CITY OF ALBUQUERQUE

October 24, 2012

**Re: La Vista Subdivision Lots 9A, 9B and 9C, Grading and Drainage Plan
Engineer's Stamp Date 10/18/2012 (C19/D042)**

**GRADING AND DRAINAGE PLAN FOR LOTS 9A, 9B, 9C**

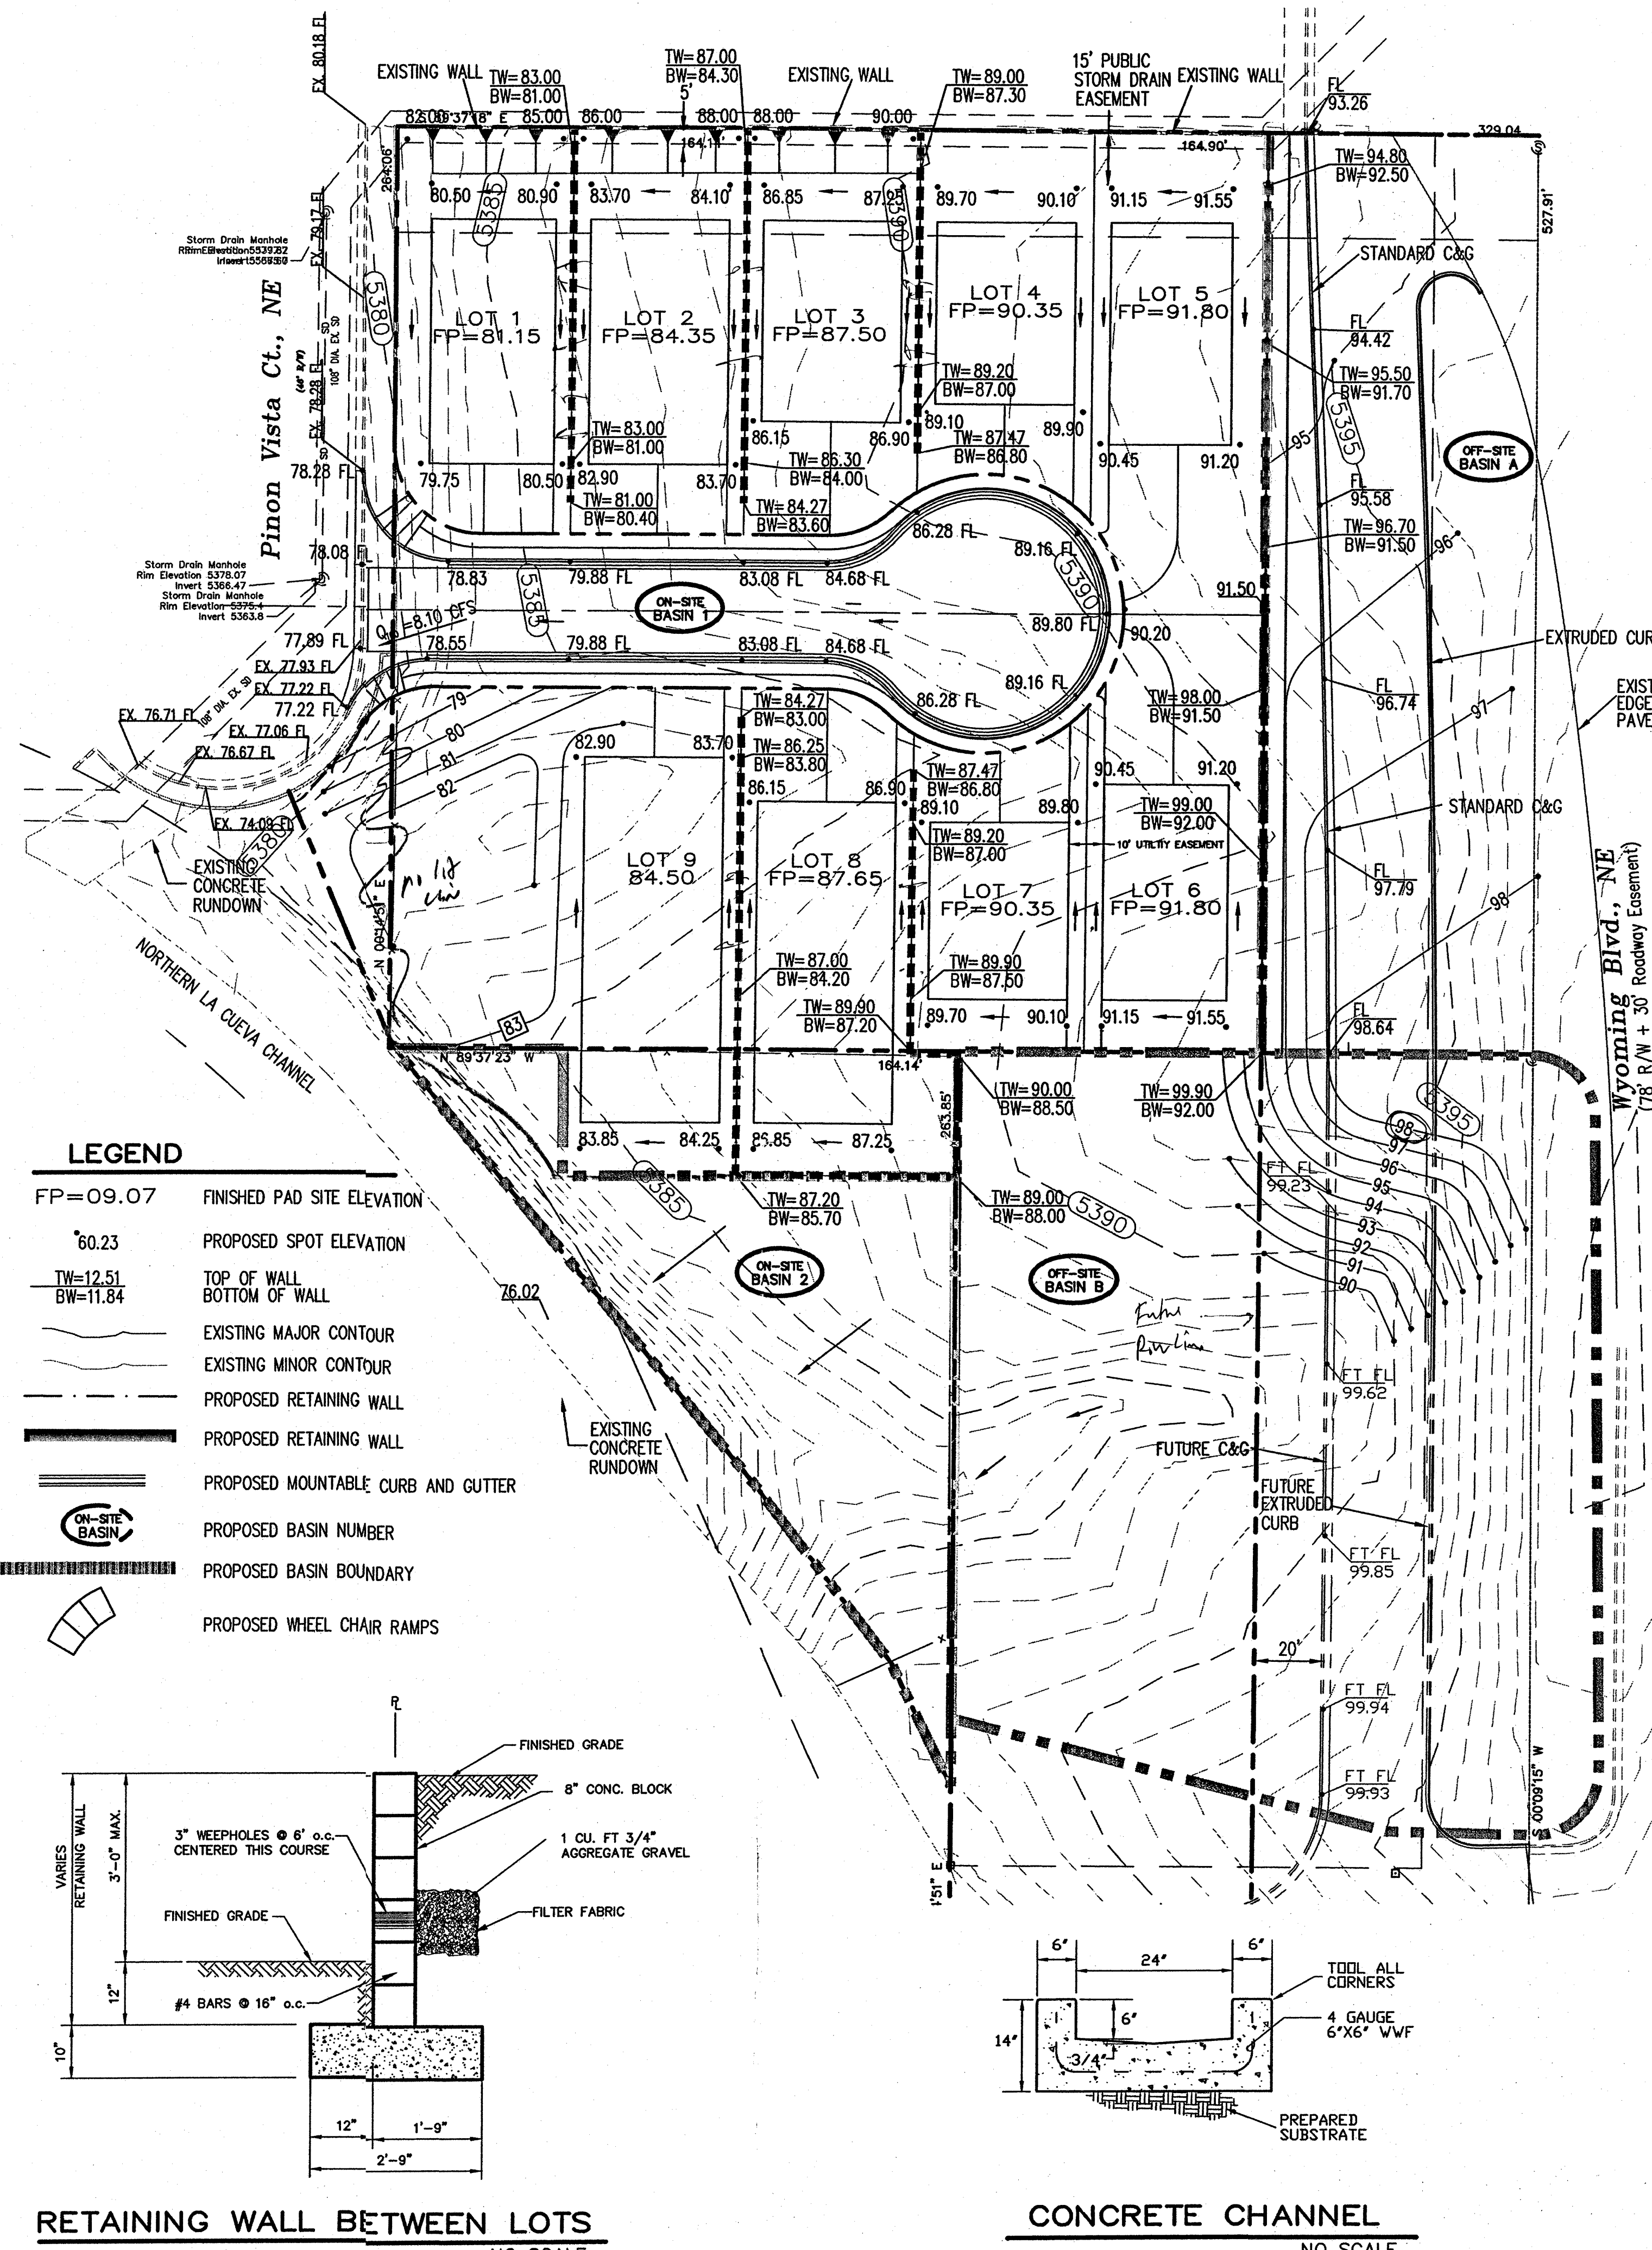
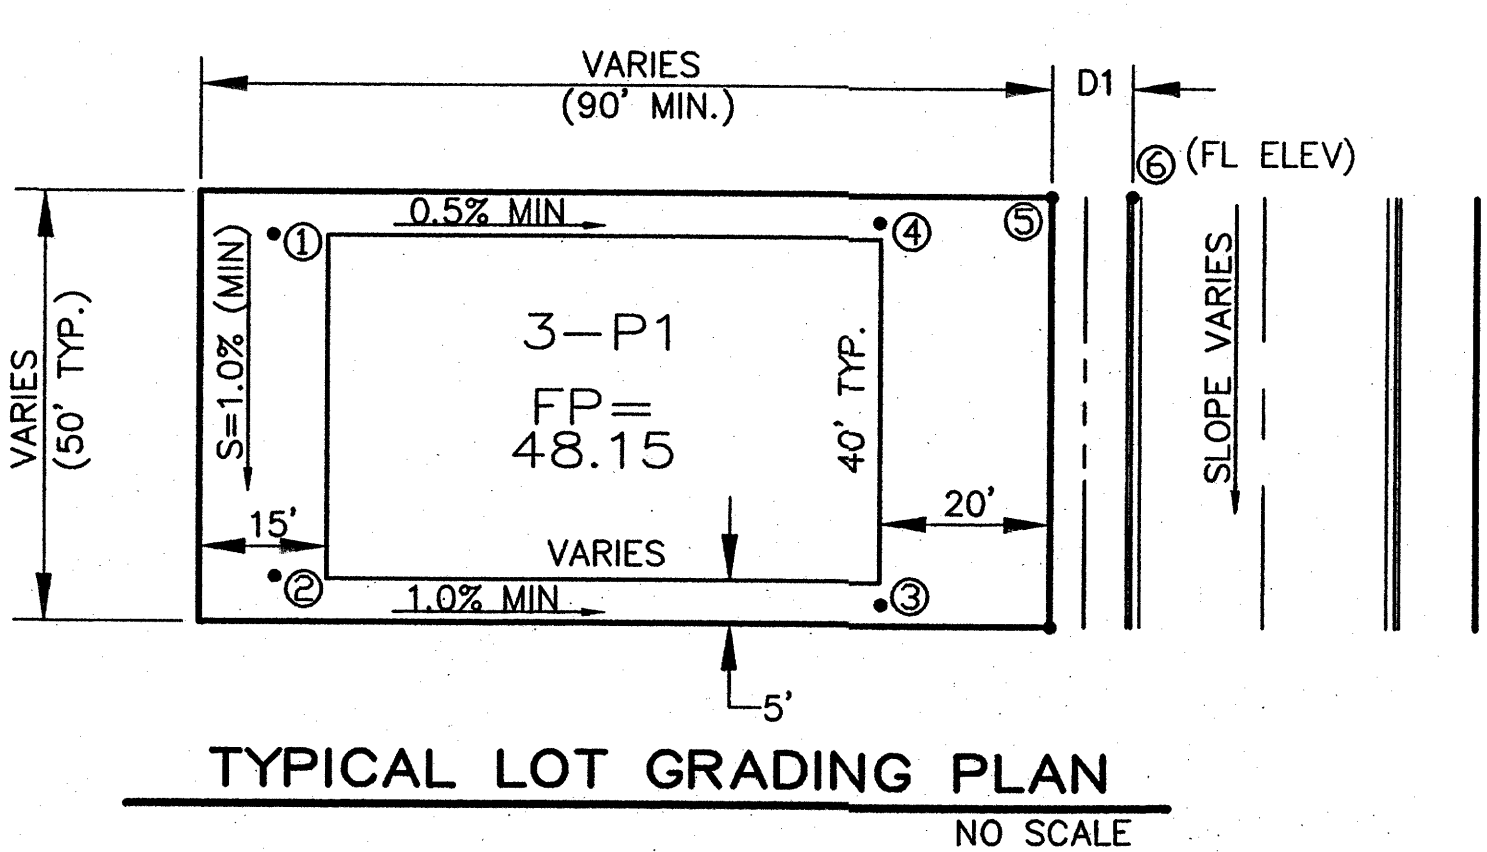
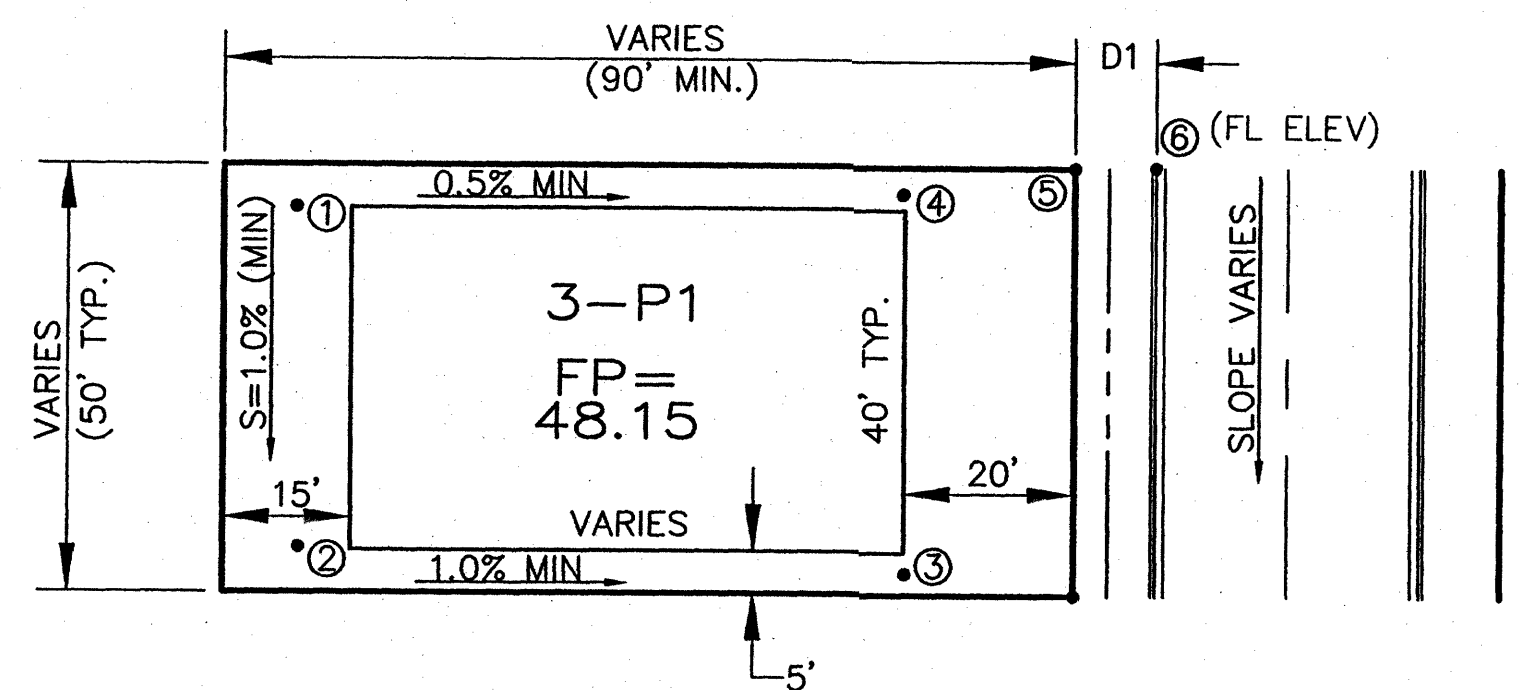
- It appears the drainage at the south end of Lot 9C will turn west into the AMAFCA ROW rather than draining south, unless a berm or similar is graded in the AMAFCA ROW. This may be acceptable with AMAFCA approval.

- The opening size in the west wall of Lot 9C should be sized, be above grade and have filter fabric to prevent sediment from leaving the site. In addition, it is a 5 foot drop to the other side of the wall, which will erode the footer and cause erosion in the AMAFCA ROW.

- At the northeast corner of Lot 9C, the wall grades are proposed at TW=84 and BW=78. A BW=78 is too low on the north side of the wall. Perhaps a TW/BW on the western wall and an addition TW/BW on the northern wall is appropriate.

- It appears the southern portion of Lot 9B will drain west to the AMAFCA ROW.
- Per the La Vista Subdivision Grading Certification, Offsite Basin A and B drain towards Lot 9C. When summed, these two basins produce 5.07 cfs. The above referenced plan specifies one offsite basin producing 3.45 cfs. Please clarify.

- Please remove the apparent ease-west property line across Lots 9A, 9B and Lot 8.
